# ENG-CDR20005-R9-CDs-Vollmer.pdf Markup Summary

**VOLLMER ROAD SOUTHERN TIE-IN TO EXISTING**

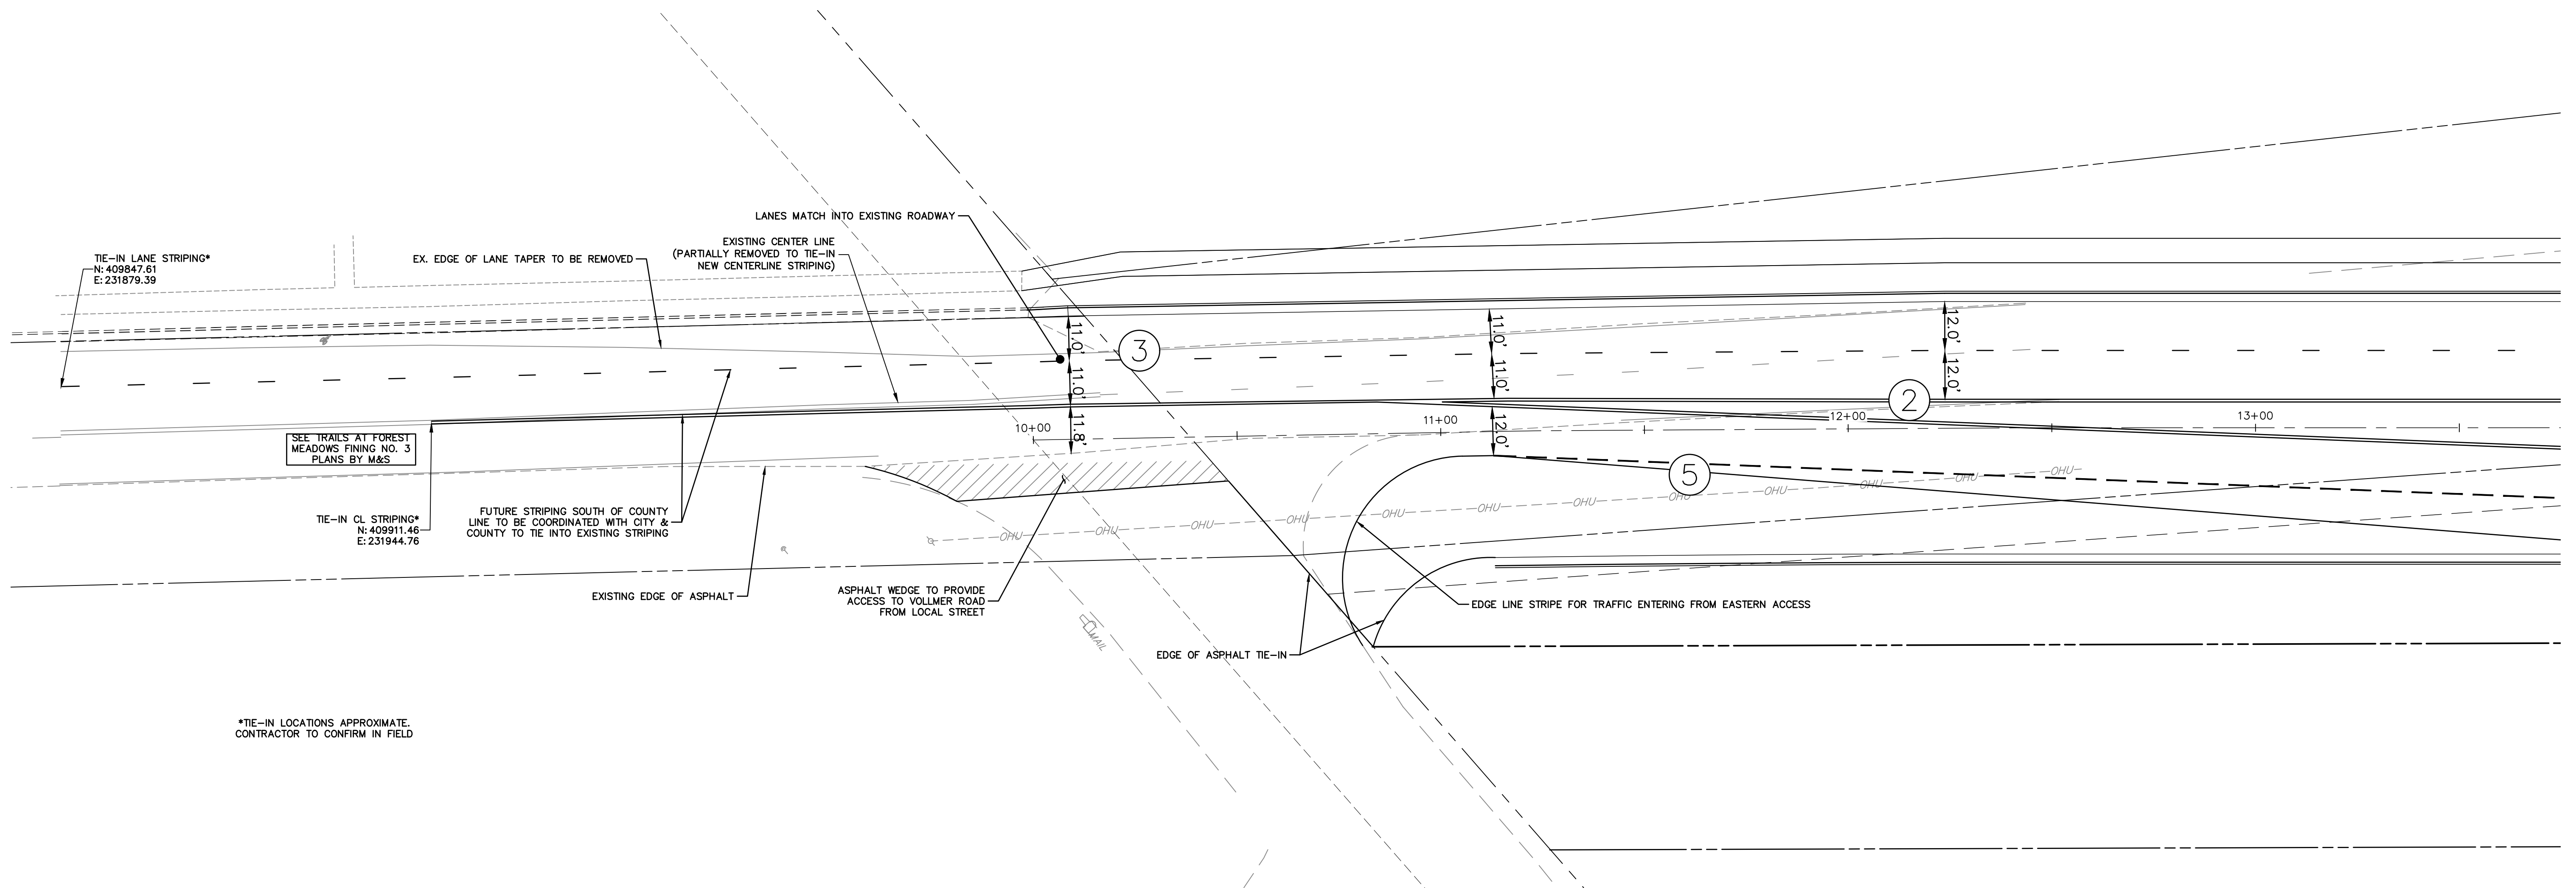
Redirects? See sheet 6

Add median signage including no U-turn, one-way....

move sign

Shift curb 1' over and taper at beginning

Cara Dawn View (existing sign)?

Delete this note.
